**Consultation Response from KC,  
Highways Development Management****2023/92608 Carr Lea House, 56, Rawthorpe Lane, Dalton, Huddersfield, HD5 9NU****Change of use from one dwelling to two dwellings****Date Responded: 09/01/2024.****Responding Officer: D. Stainsby****Responding Ref: K5-11SE/12**

This application is for the change of use from one dwelling to two dwellings at 56 Rawthorpe Lane, Dalton, Huddersfield.

SITE ARRANGEMENT PLAN.
SCALE 1:200.

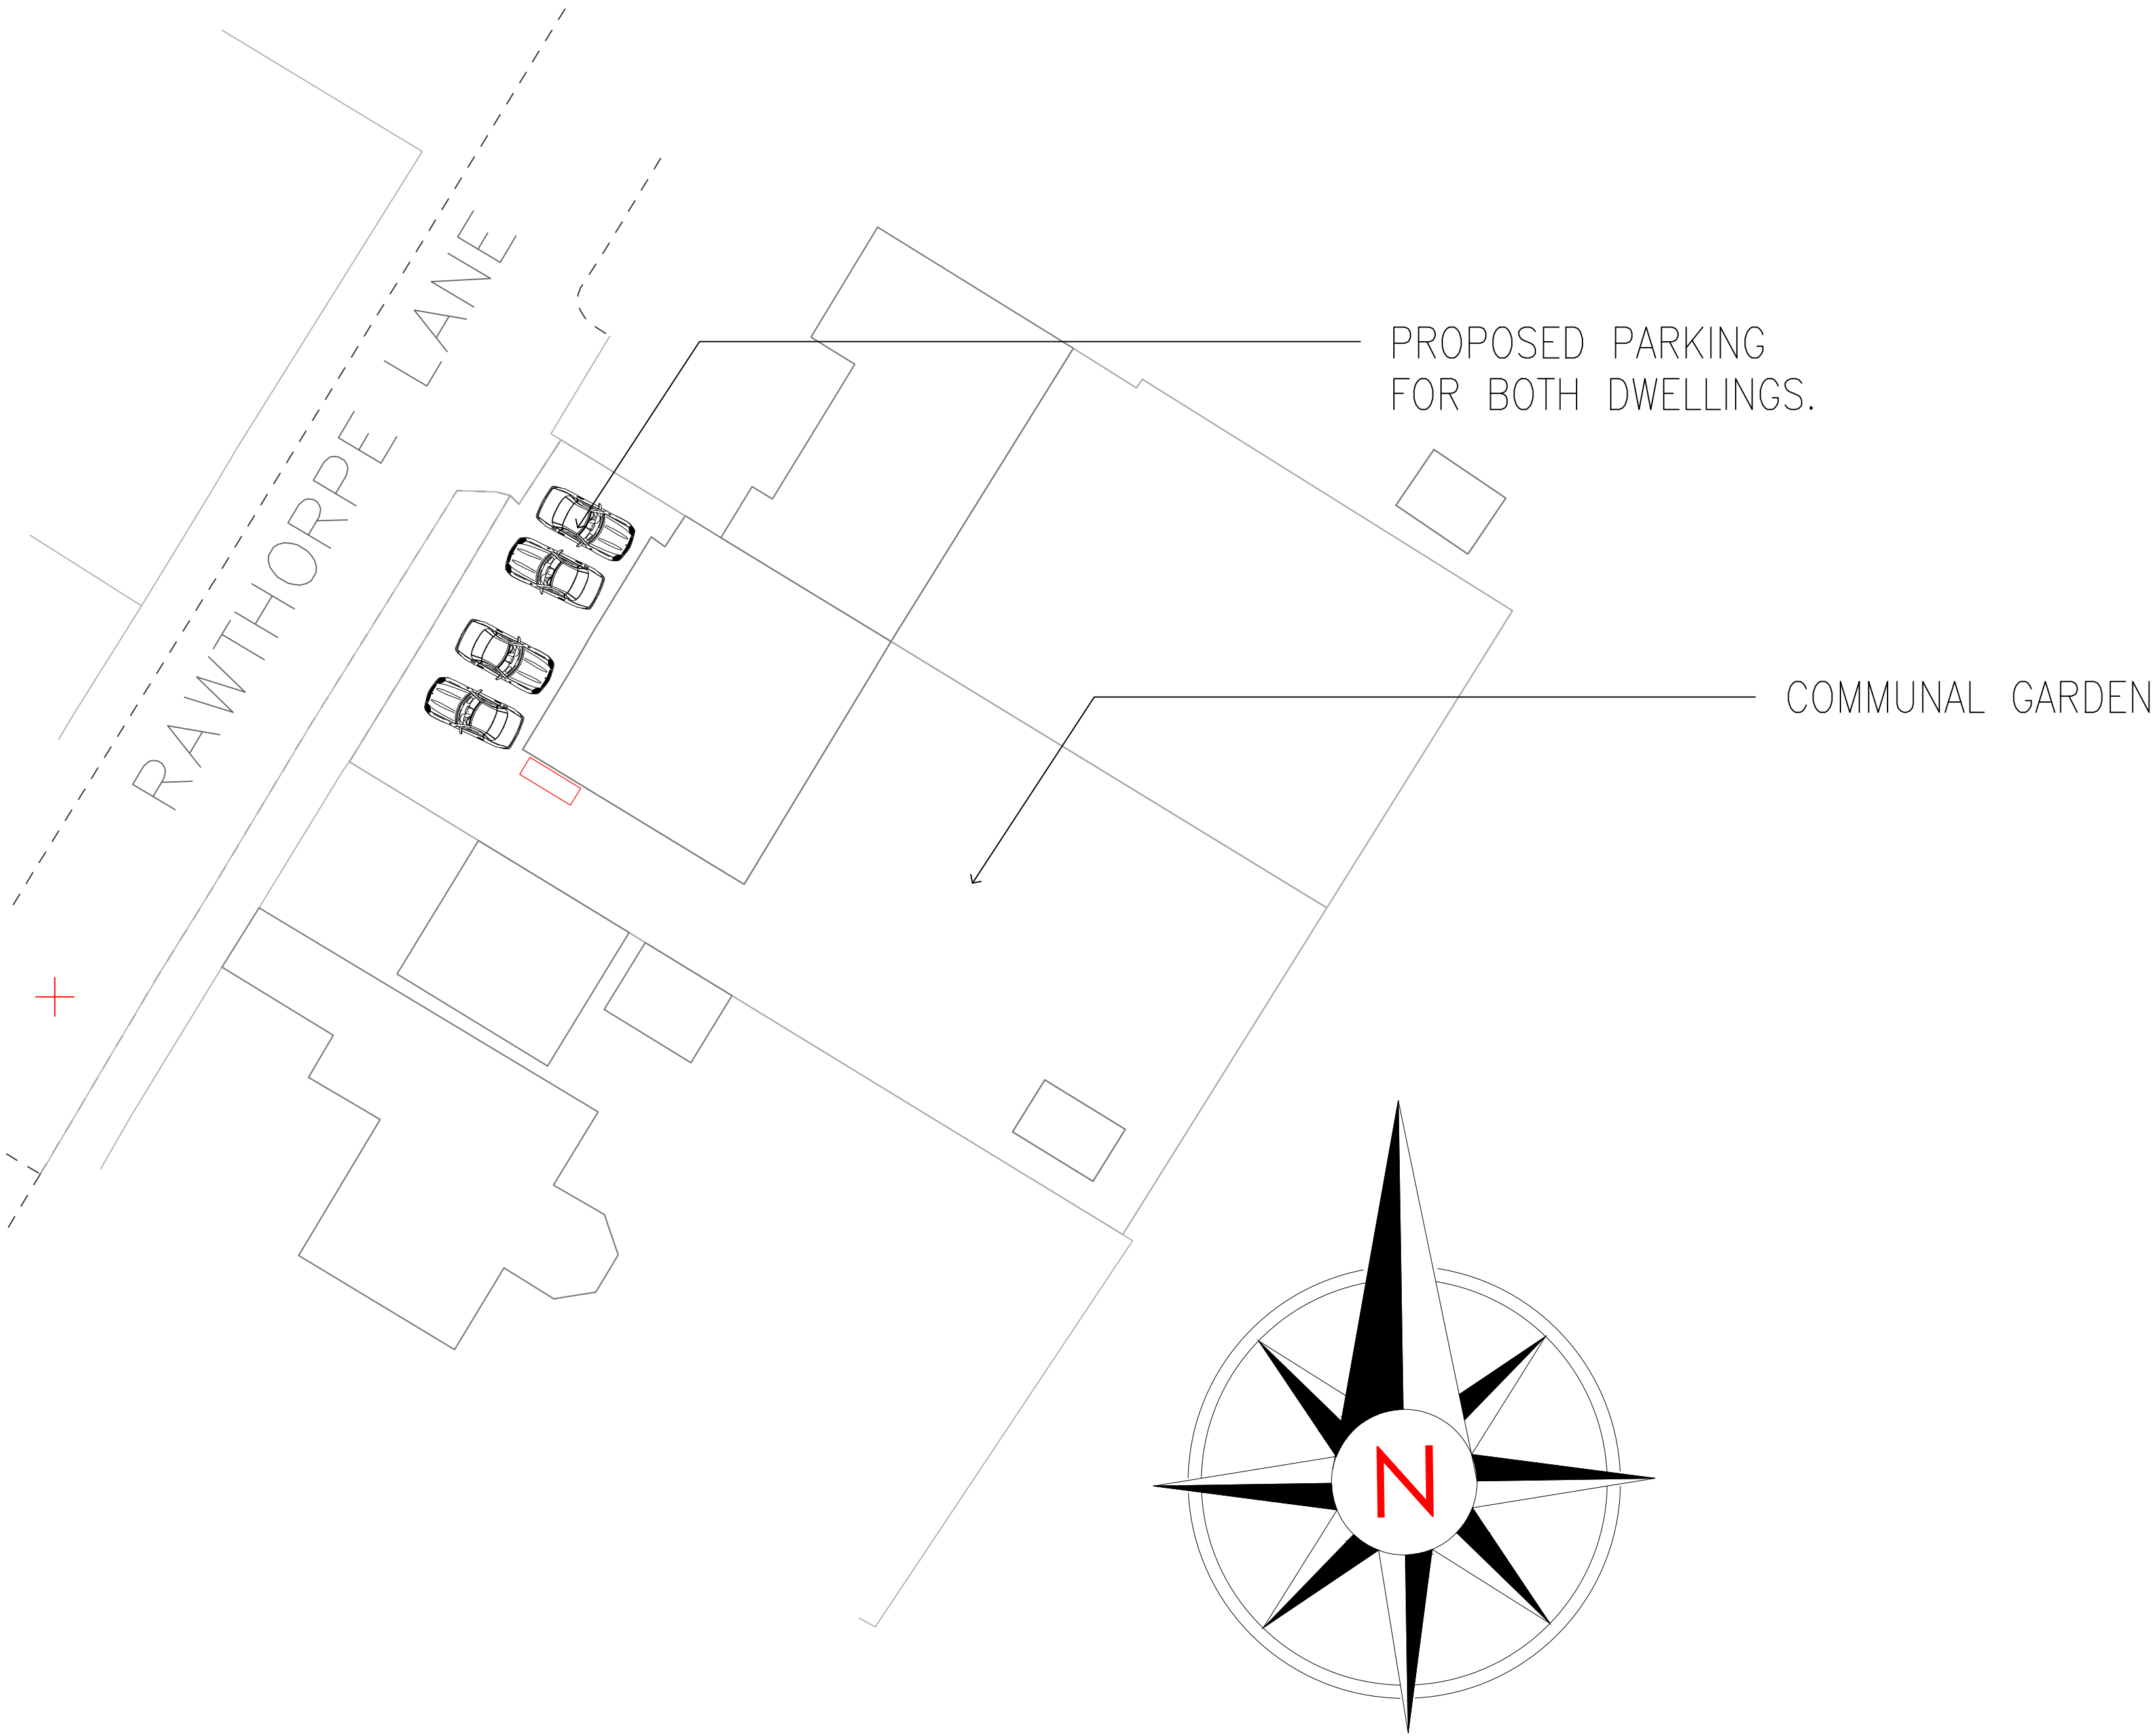
Access to the proposed development is taken via the two existing accesses.

There is sufficient parking indicated for the proposed dwelling and existing dwelling so is considered acceptable in that respect.

The approved vehicle parking areas will need to be surfaced and drained in accordance with the Communities and Local Government; and Environment Agencies 'Guidance on the permeable surfacing of front gardens (**parking areas**)' published 13<sup>th</sup> May 2009 (ISBN 9781409804864) as amended or superseded.
